TO: DRB Chairwoman Wolfley & DRB Members
FROM: District 4 Coalition's Zoning & Development Committee
Peggy Neff, Jim Griffie & Dan Regan, Chair
DATE: 3/29/21 -- **REVISED 4/7/21**
SUBJECT: Project 2019-002761 – The Peaks by Markana

Project 2019-002761 – The Peaks by Markana

LANDSCAPE PLAN

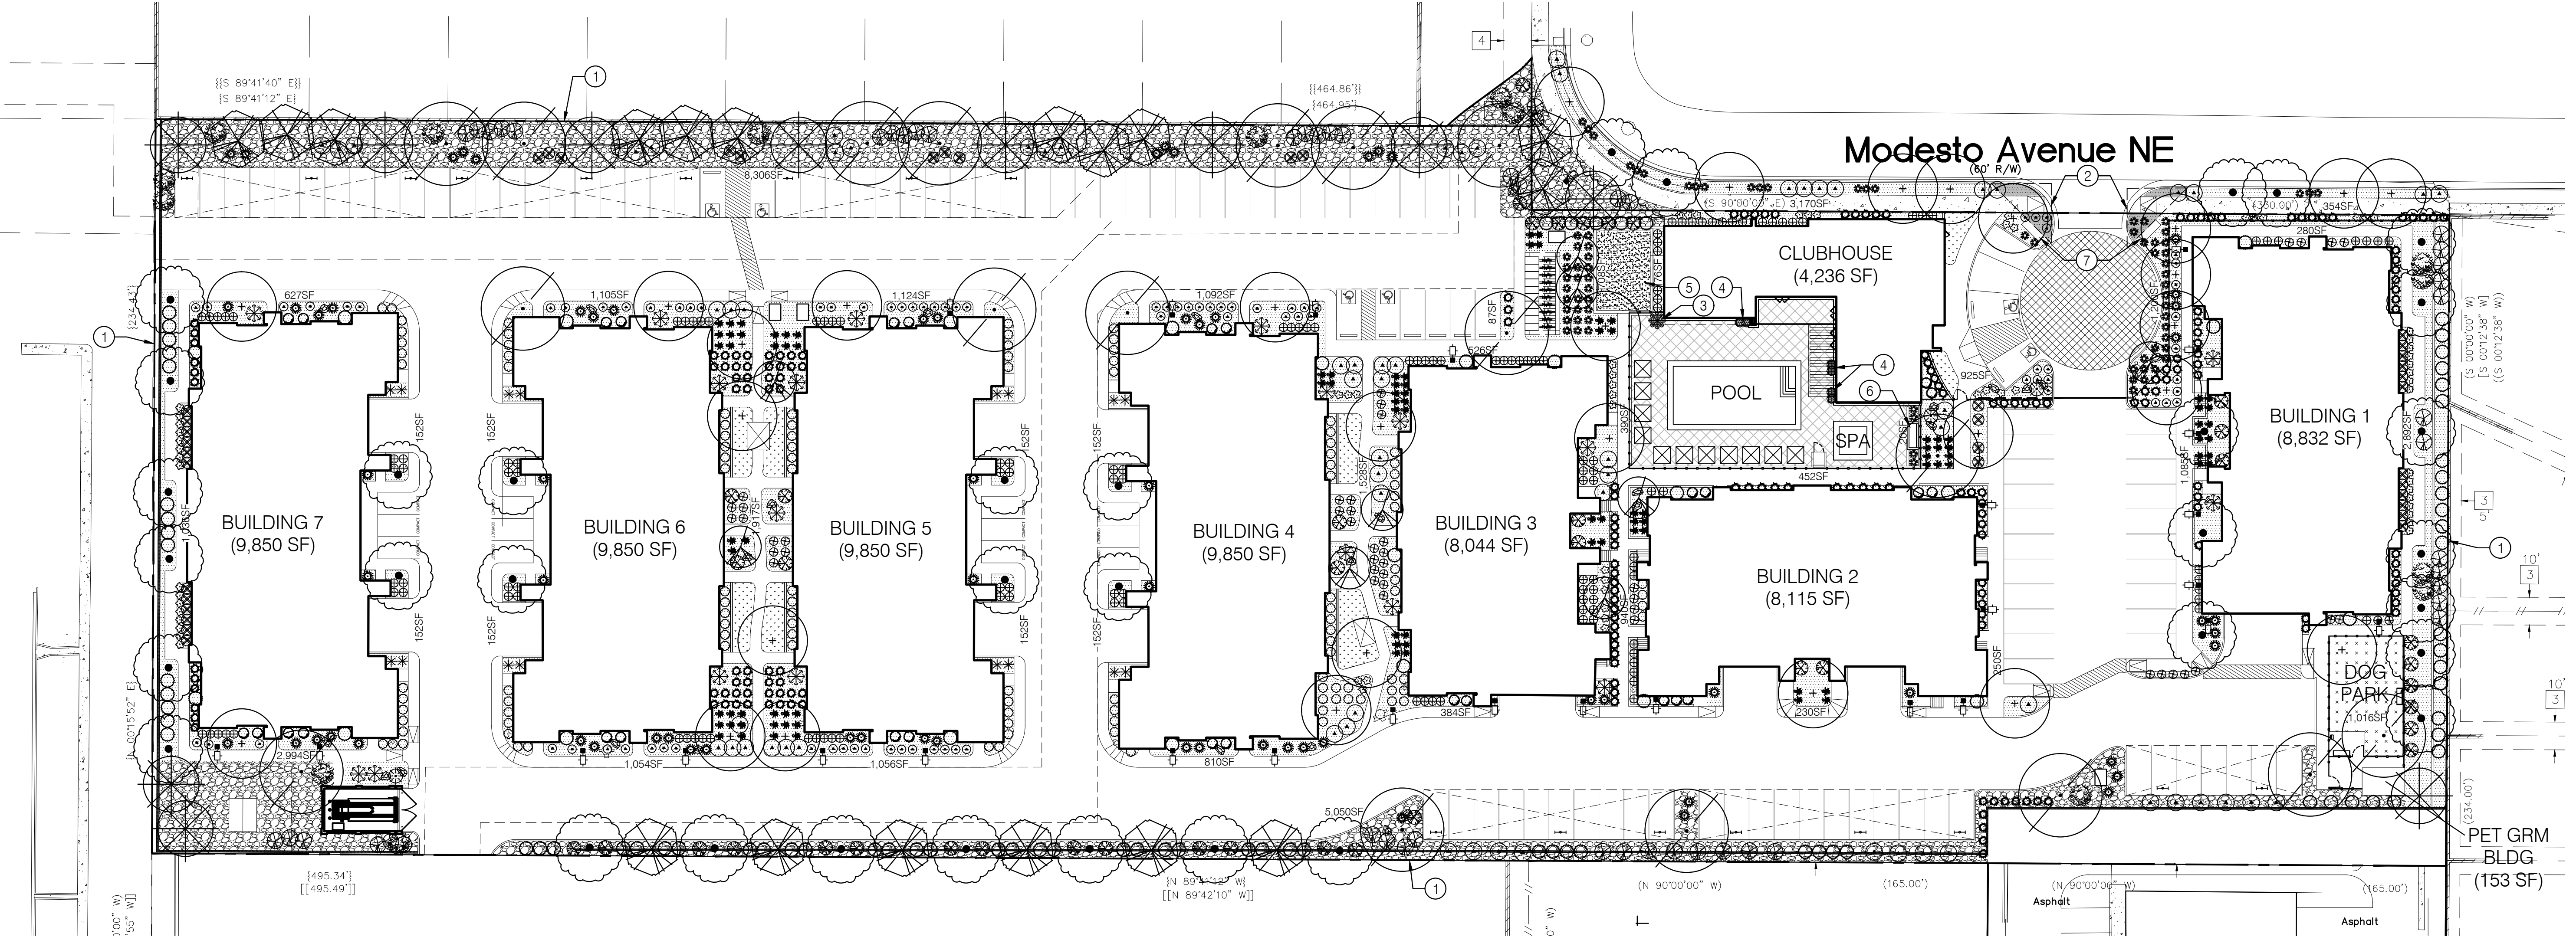
The current Site Plan for The Peaks has 120 apartments with 174 beds (in the breakout of single & double bedroom apts.). The developer/agent are required to have 180 parking slots; they are requesting the ability to only provide 174 parking slots (one per bed, conveniently) with NO ACCOMMODATION for ANY visitor parking! If one looks carefully at the immediate surroundings of The Peaks, it is pretty clear that off-site parking of either occupants or visitors will automatically create problems for other residents, both home owners and businesses. The developer would not commit to language in the leases for the Peaks that restrict vehicles to one auto per bed and simply stated that there should be room for Visitors to park. This is not only unrealistic; it borders on the ludicrous! The suggestion that the furthest east apartment building be eliminated or halved and parking be installed there was met with “that won’t work”.
